Online Comment

Application H08-0520-20
Location 286 Siltside Gosberton Risegate Spalding PE11 4JR
Proposal Proposed extension to agricultural building

Name Black Sluice Internal Drainage Board
Address Station Road Swineshead Boston PE20 3PW

OS MasterMap 1250/2500/10000 scale
Tuesday, June 23, 2020, ID: BW1-00883479
www.walters-property.com

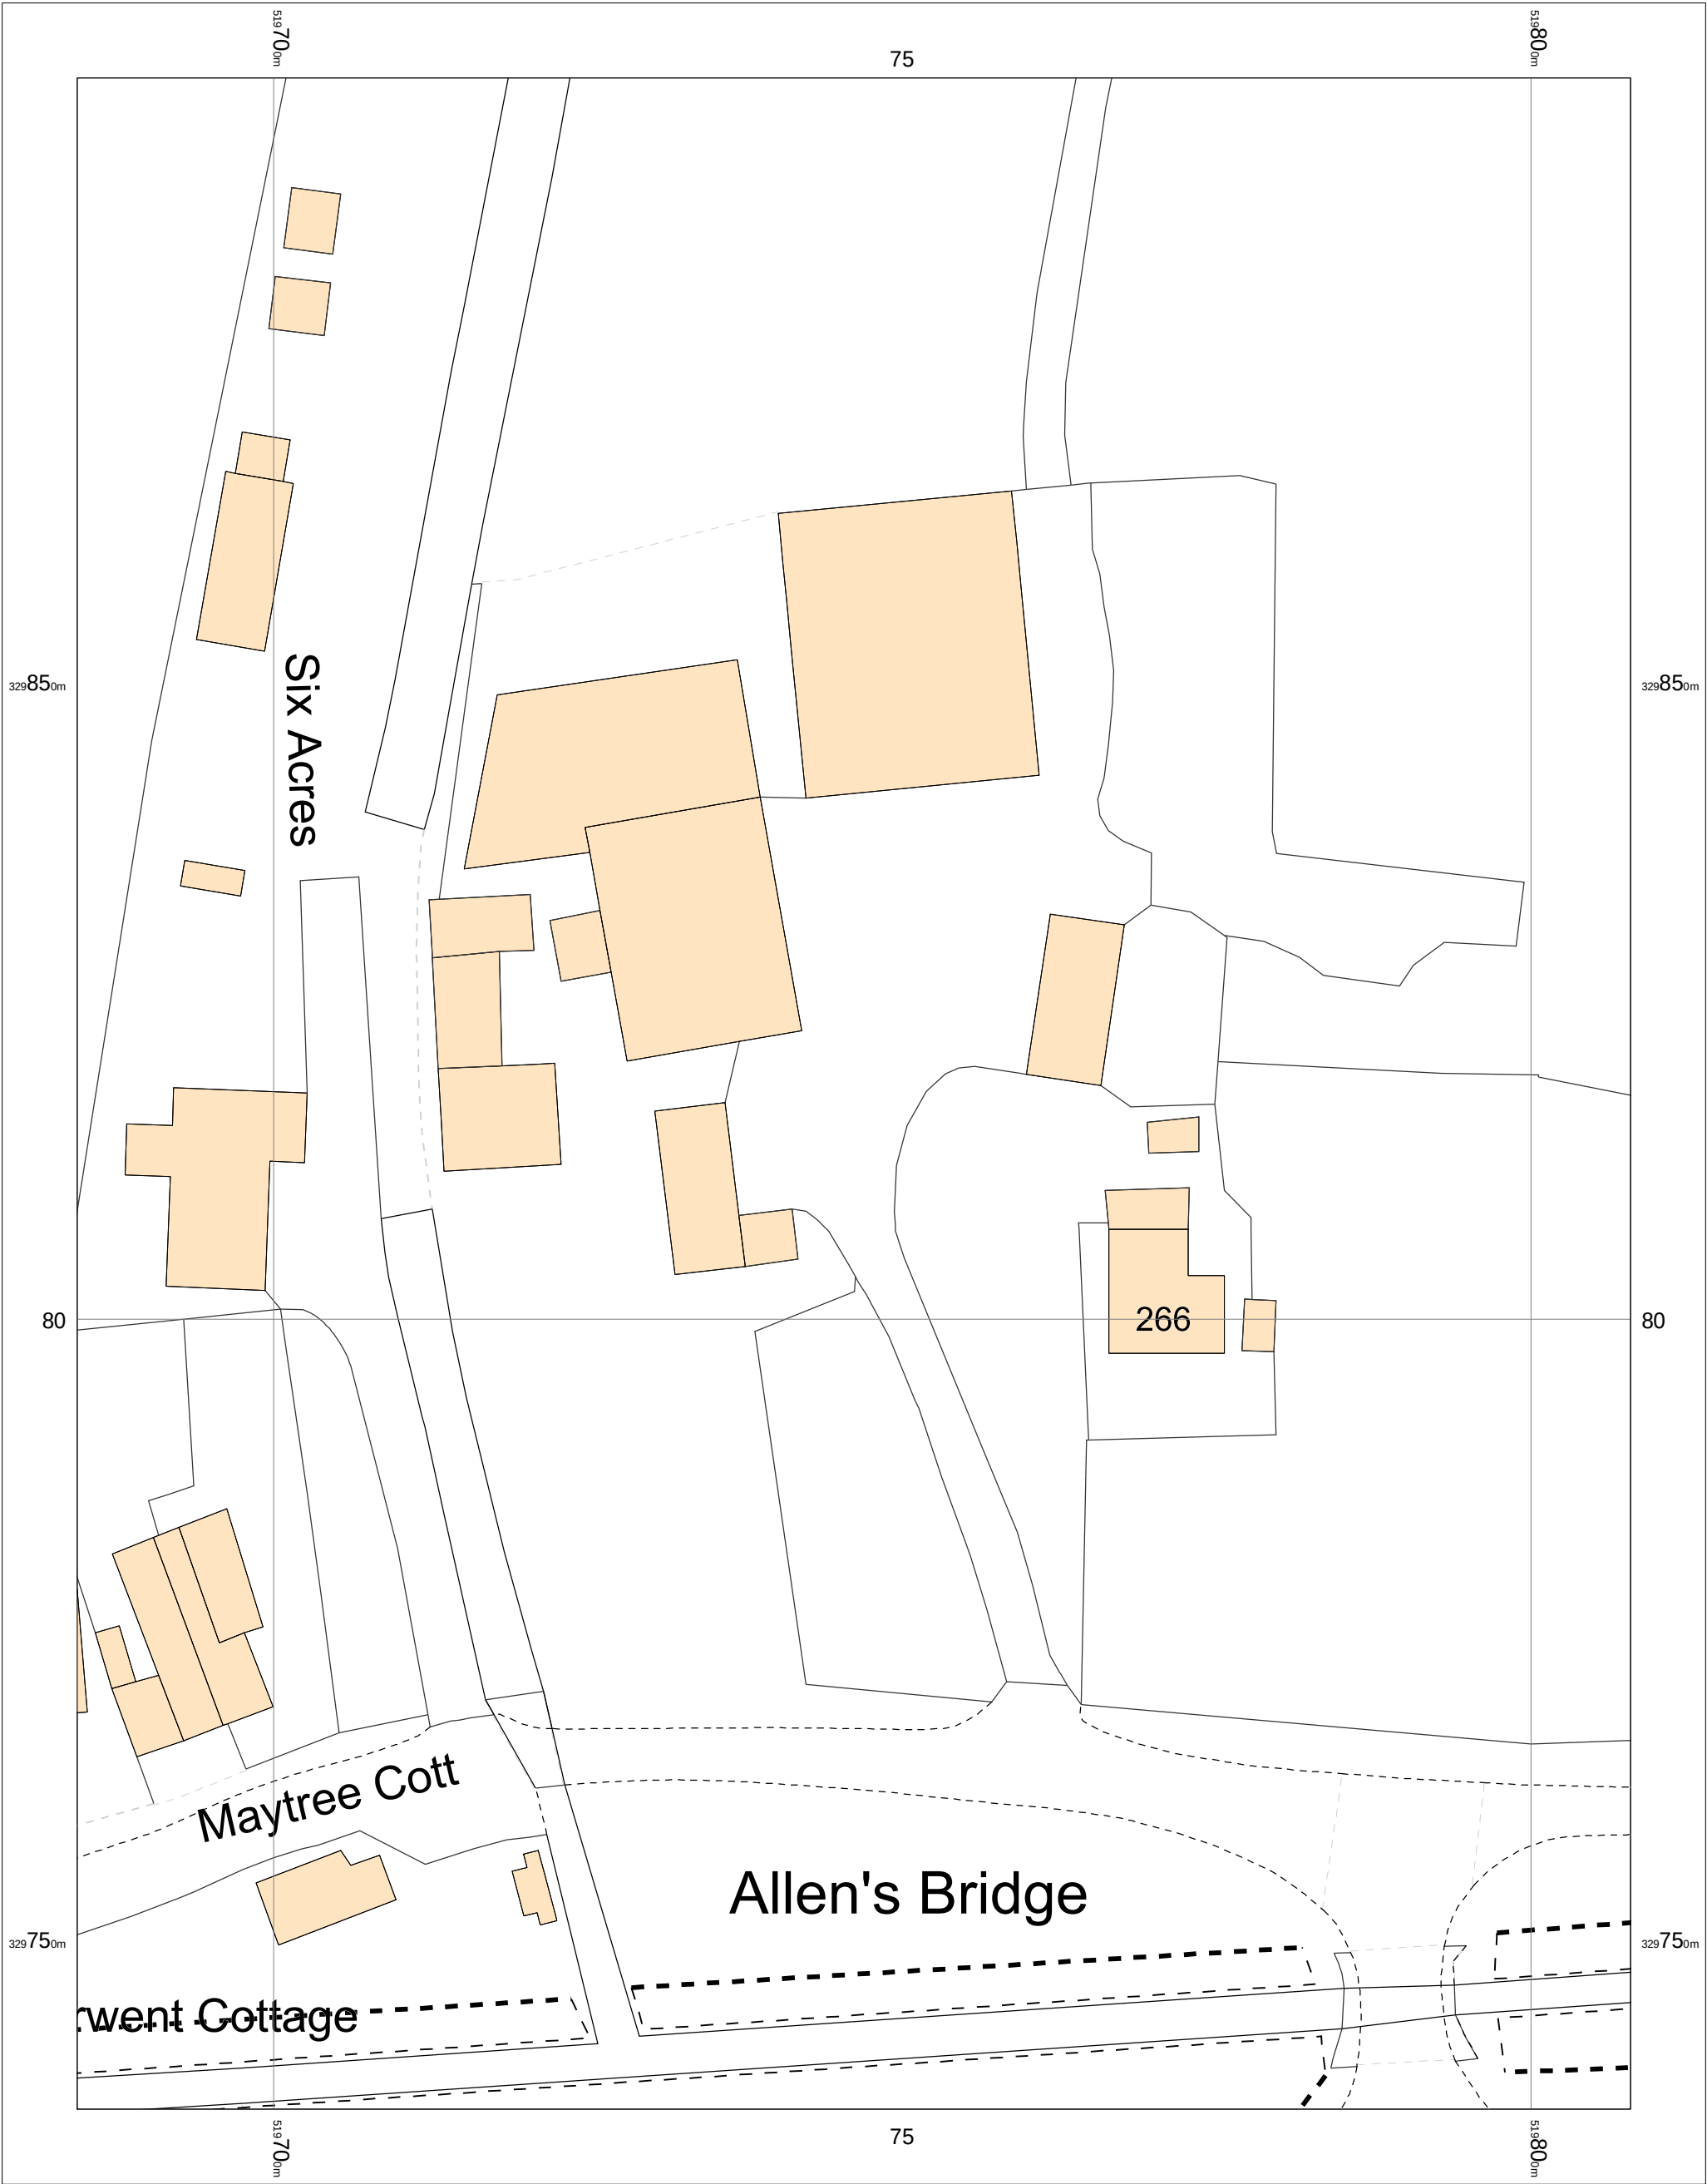
There is a Board-maintained watercourse on the western boundary of the site. The proposed development, as indicated on the plans submitted, does not infringe upon the Board's Byelaw No.10 regarding obstructions within 9 metres of the watercourse. Attention is only drawn for future reference. The applicant is reminded that clear access to this watercourse should be maintained for the Board's use during construction of the proposed structure.
